**From:** [Lloyd Hartz](#)  
**To:** [Jeff Watson](#)  
**Subject:** Proposed short plat  
**Date:** Tuesday, November 02, 2010 7:48:13 AM

My wife and I have concerns about the proposed short plat , Plain Beautiful (SP-10-00012) that has been proposed by D&H Ranch incorporated.

SHEET 1 OF 3

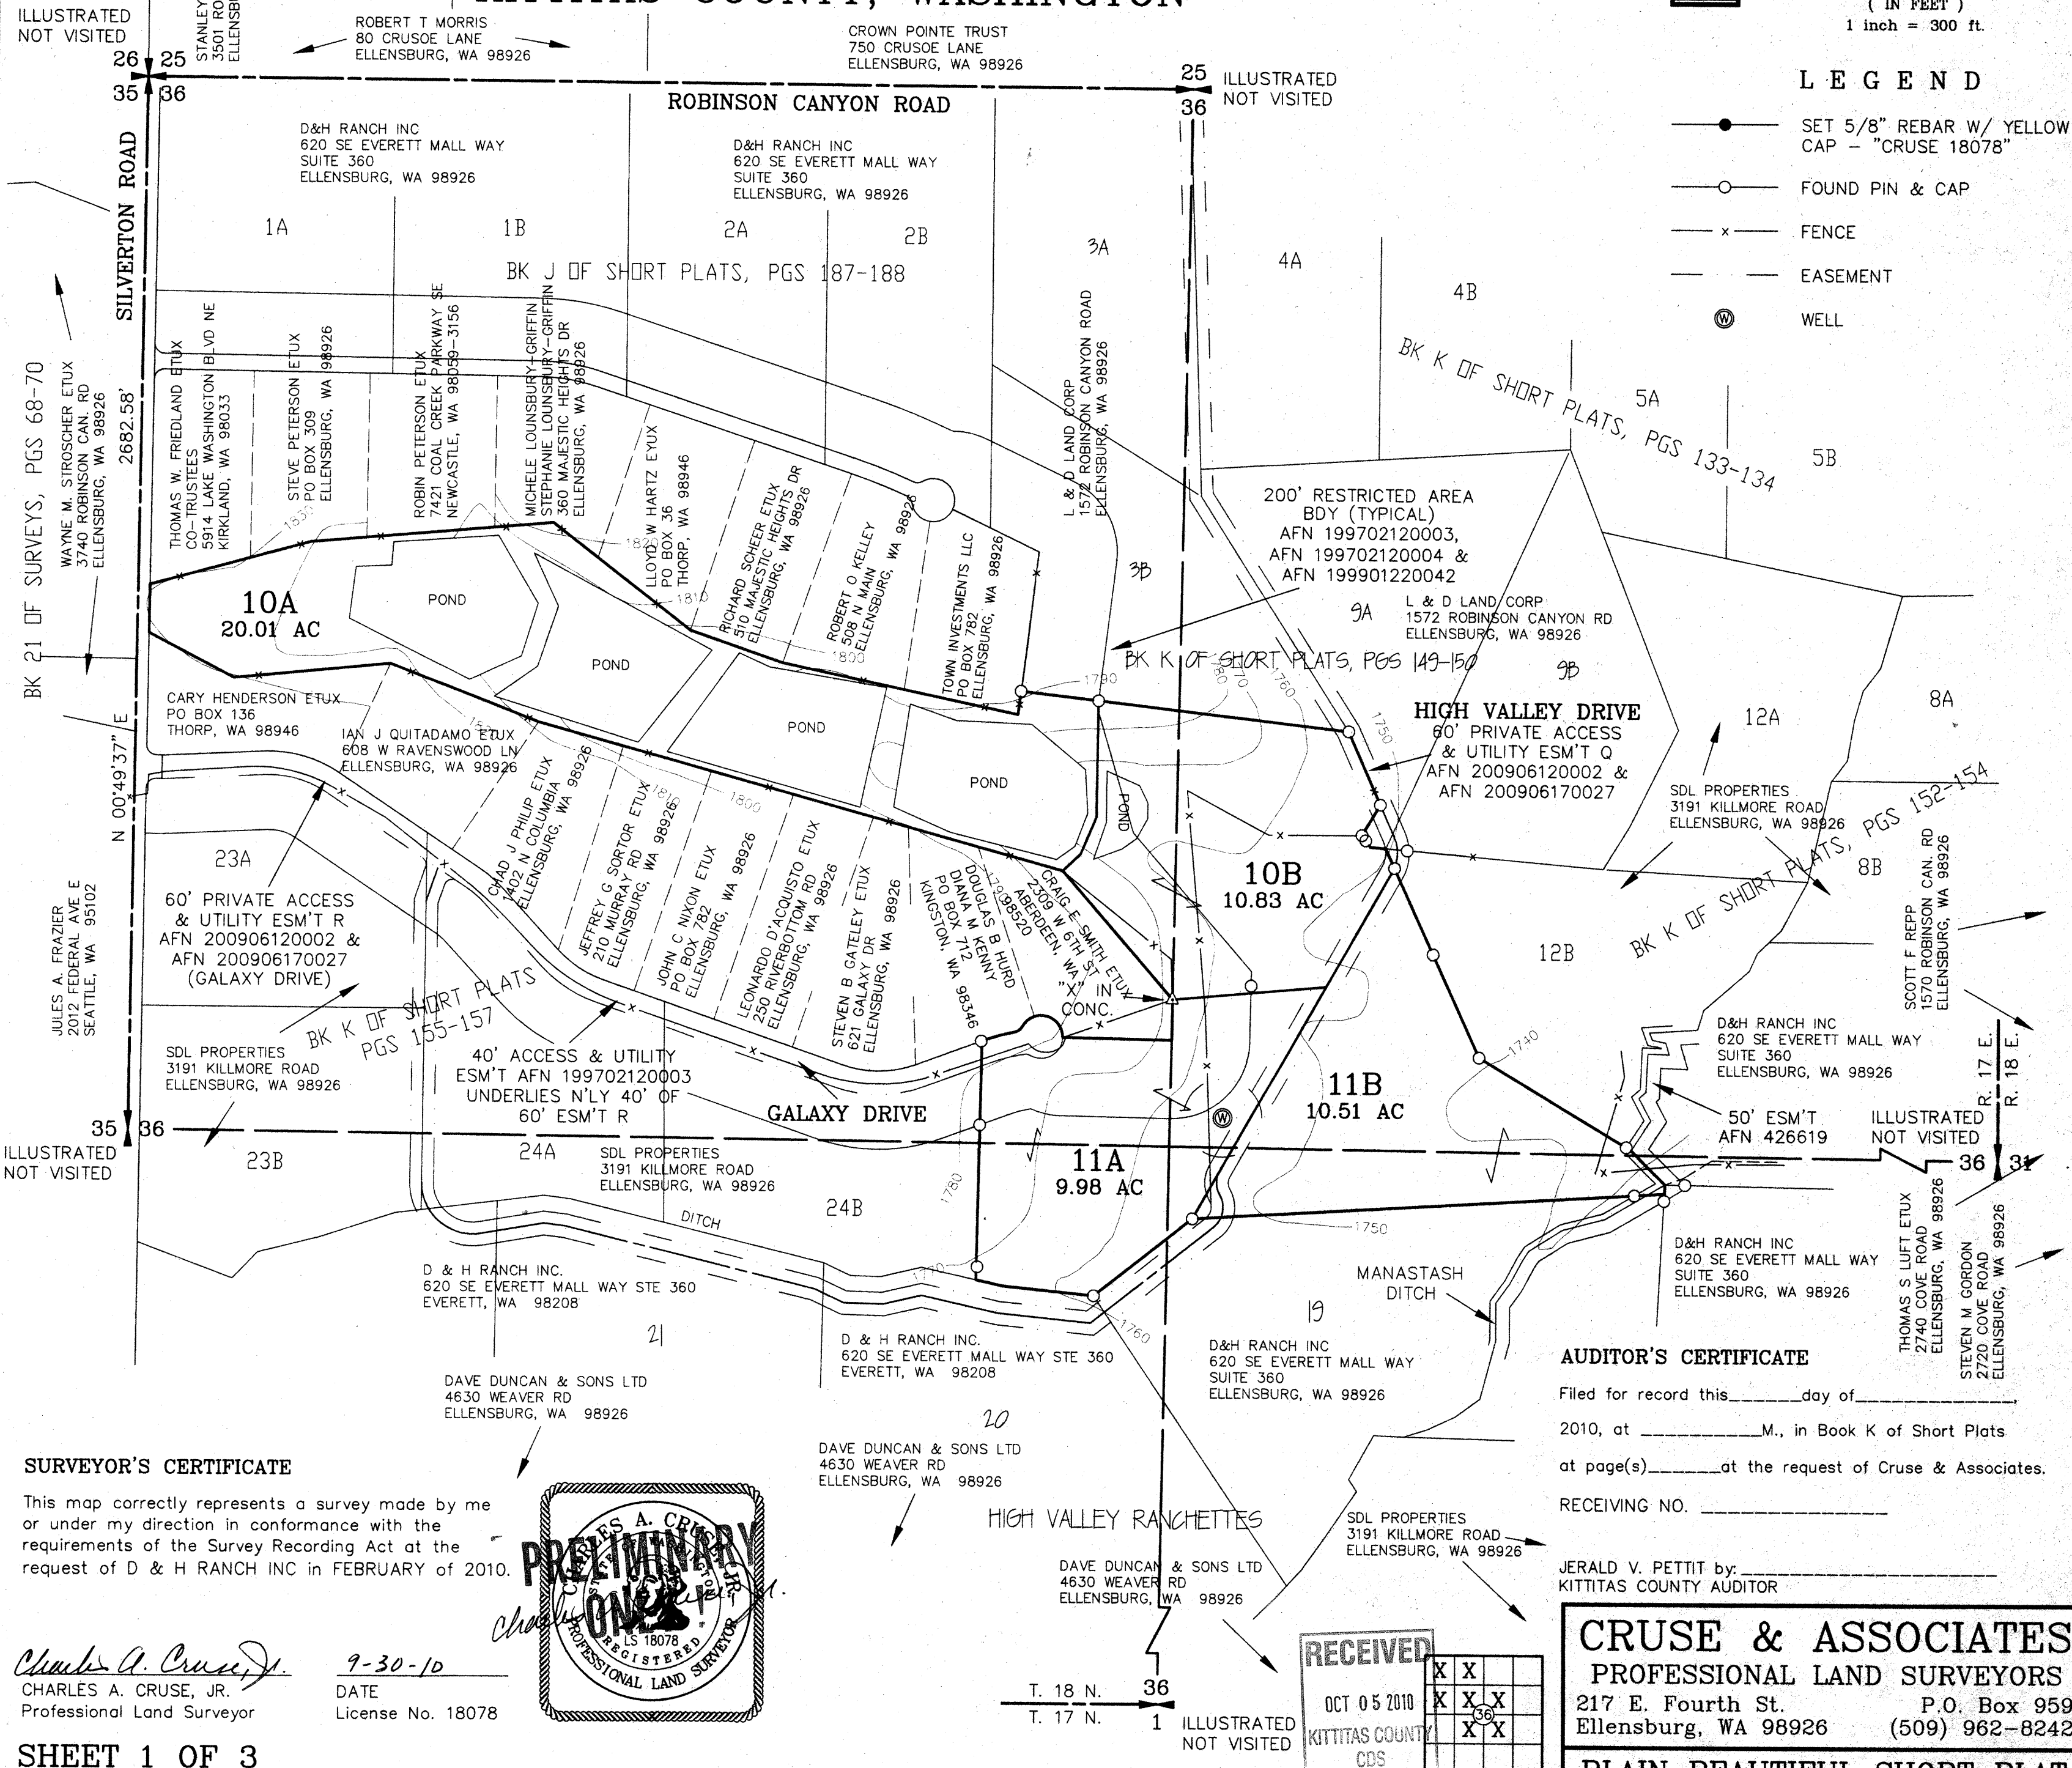
Specifically, proposed lot 10A, formally Lot 18 in the High Valley Lakes short plat, was previously denoted as an unbuildable lot.

Also, we are concerned about domestic water hookup to High Valley Lakes water system. Currently, water pressure seems to be close to minimum to residences with only 8 of 17 lots currently being serviced by the system.
